TaylorThomsonWhitting

10th July 2012

CAMPBELLTOWN HOSPITAL STAGE 1 REDEVELOPMENT

Response to Submissions

12.5m TRUCK MAKING REVERSING MANOEUVRE

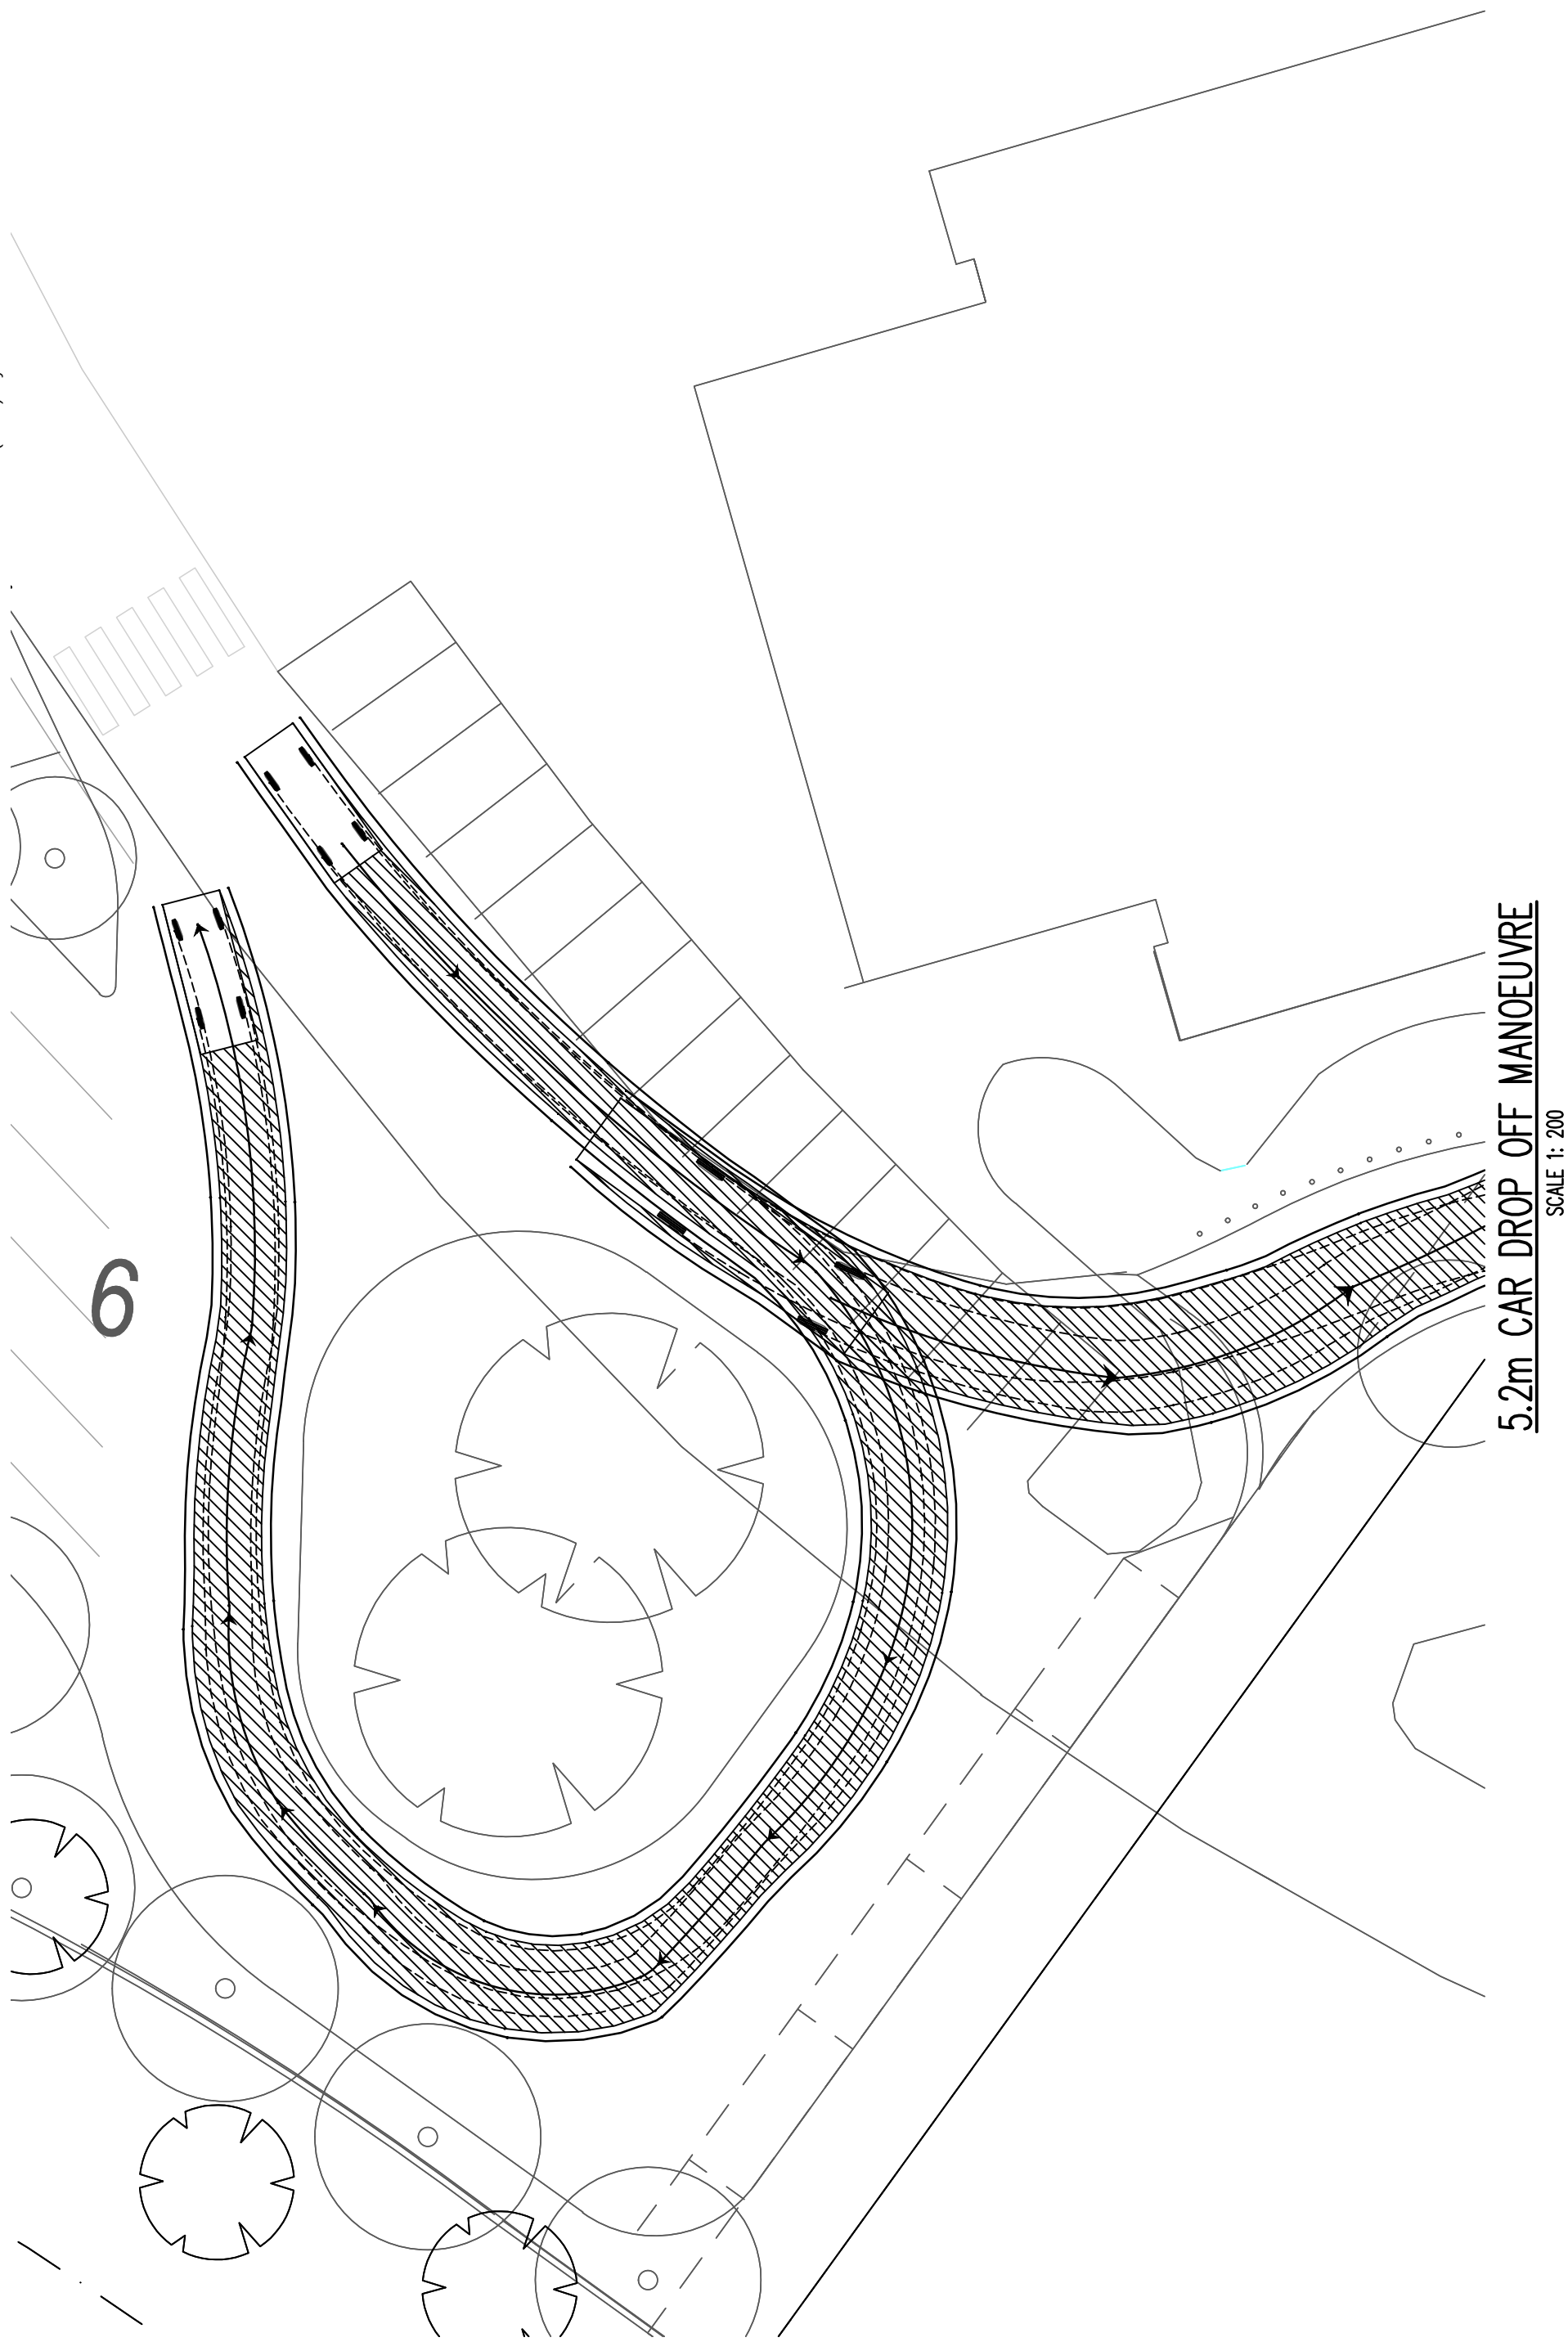
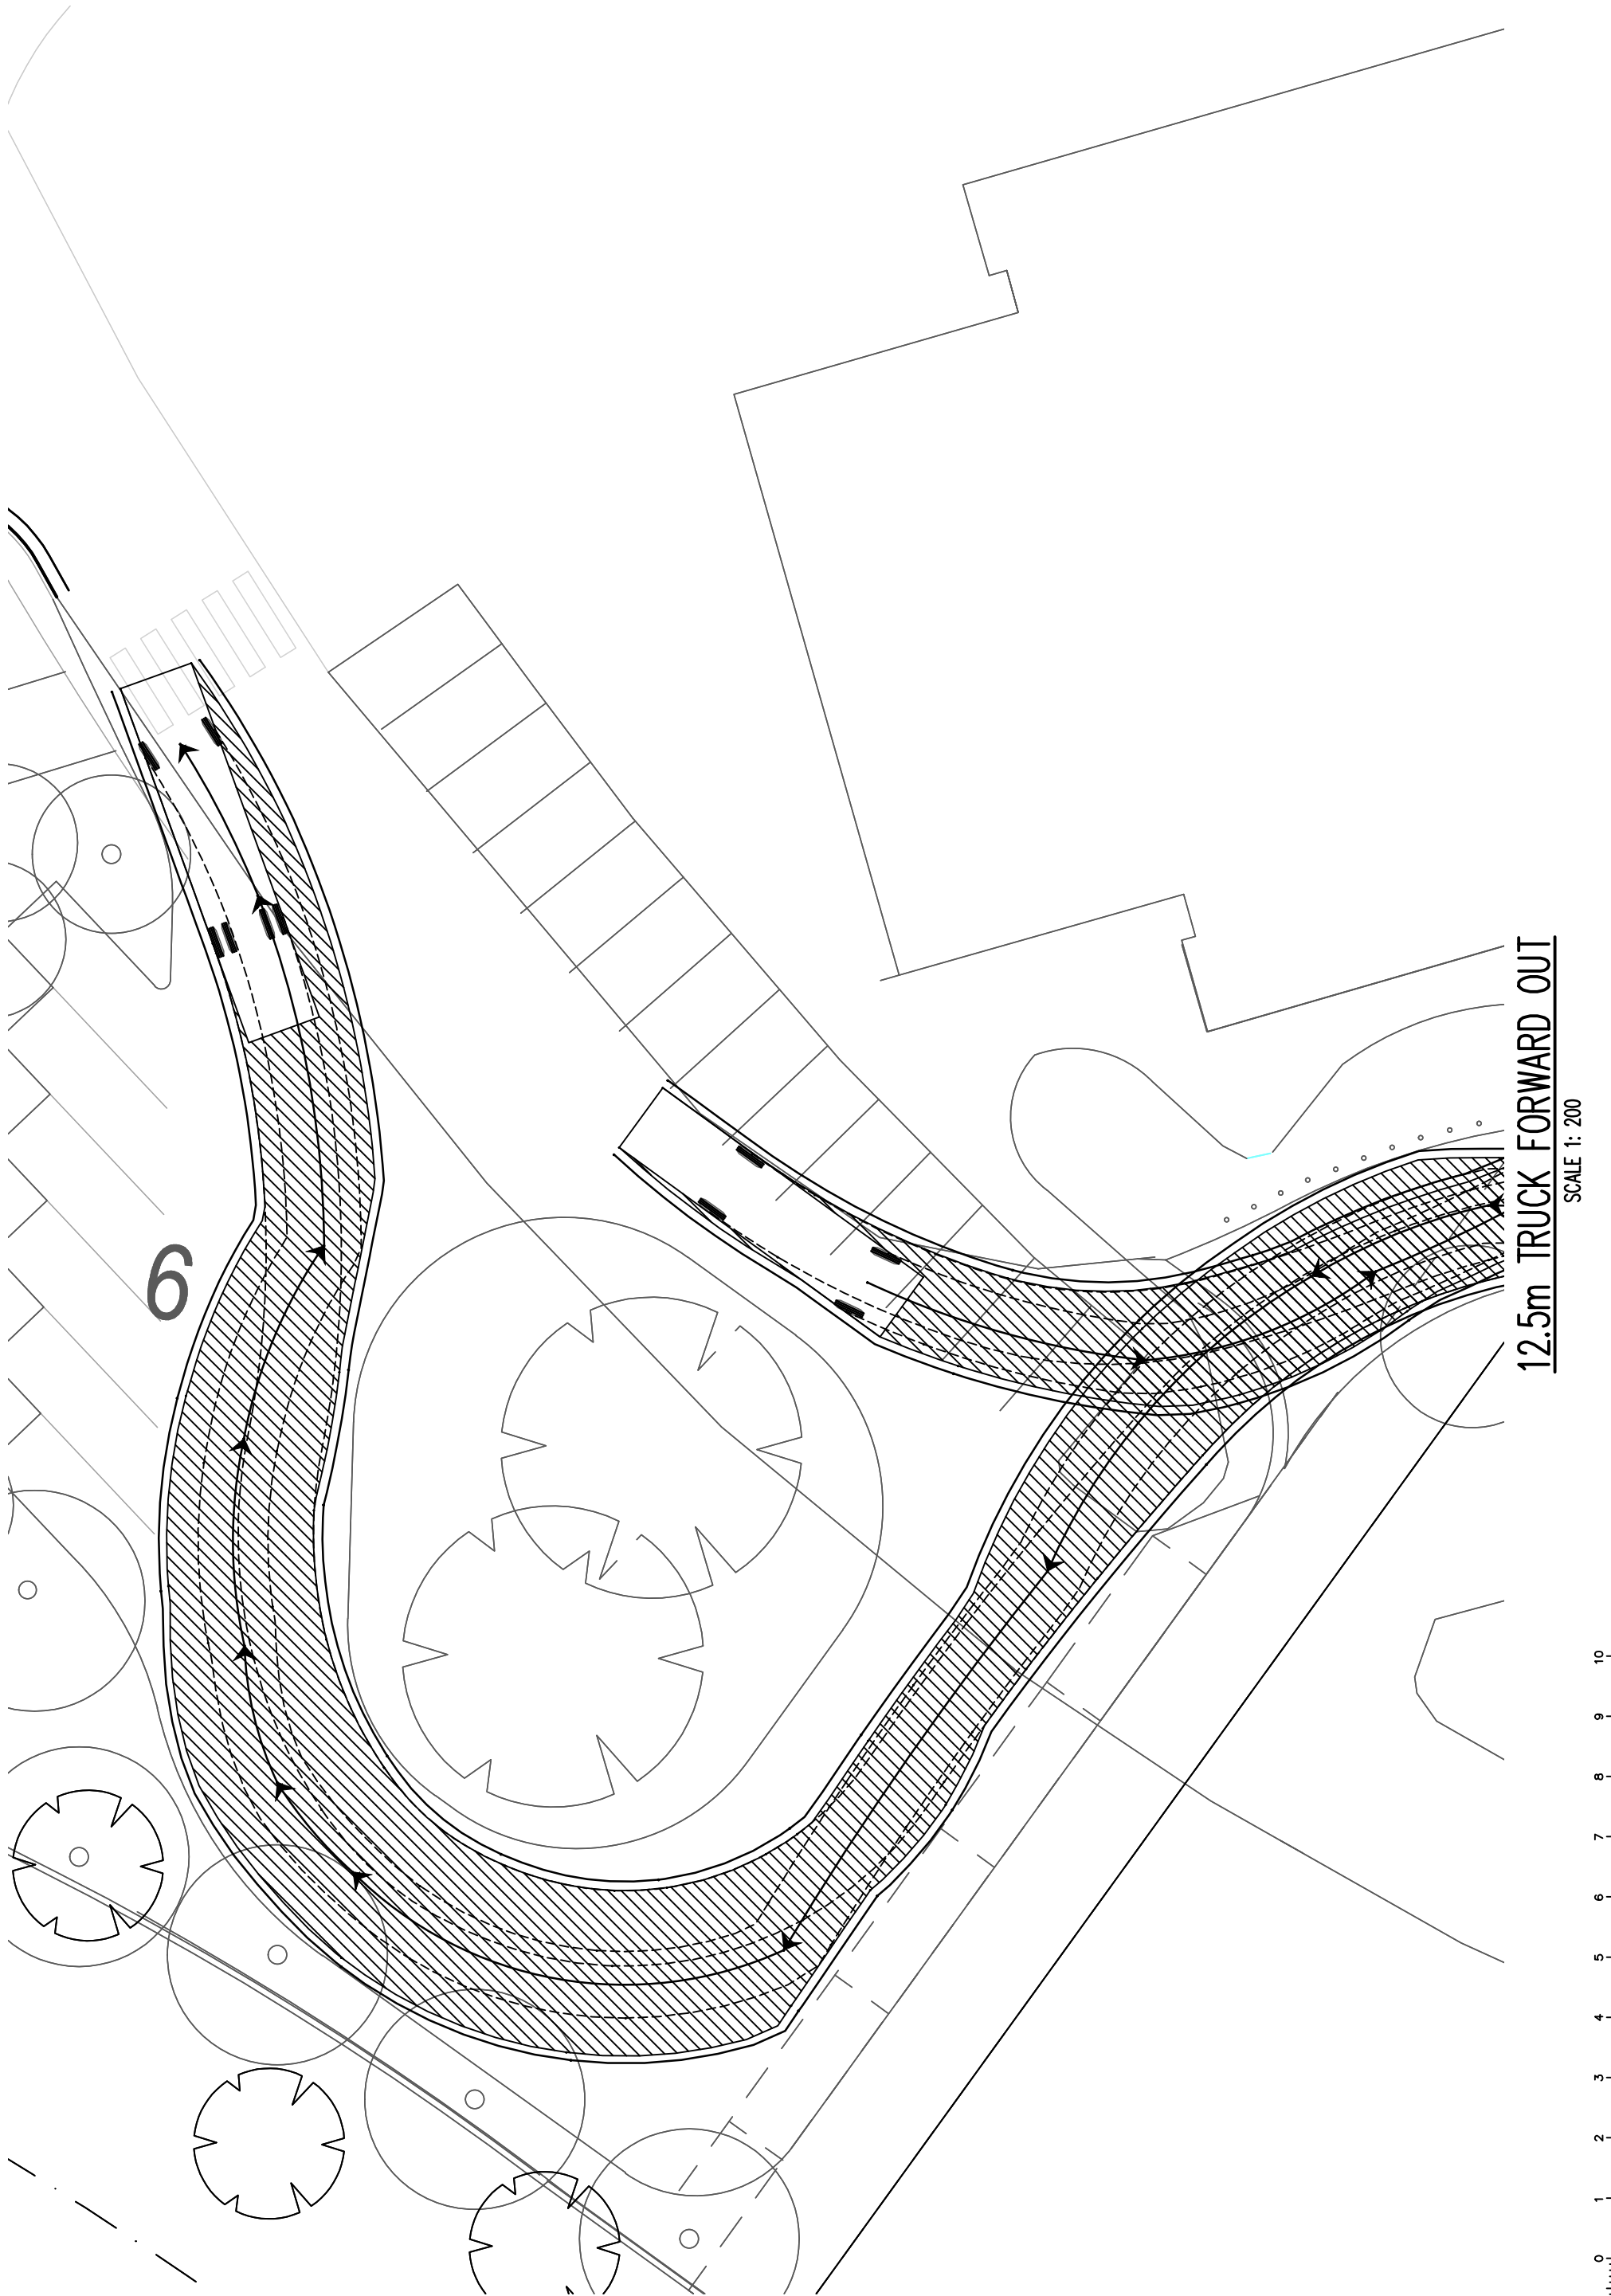
5) The traffic and parking report does not mention nor considers access for plant and maintenance.

Access analysis and turning paths have been carried out and included as part of the development application documents including loading areas. Section 4.2.2 of Traffic and Parking Report has also addressed the service vehicles access.

The use of new service access for plant room and maintenance to the site is limited (i.e. less than 10 vehicles per month) and appropriate turning paths and access arrangements are shown in Exhibition 1, attached document.
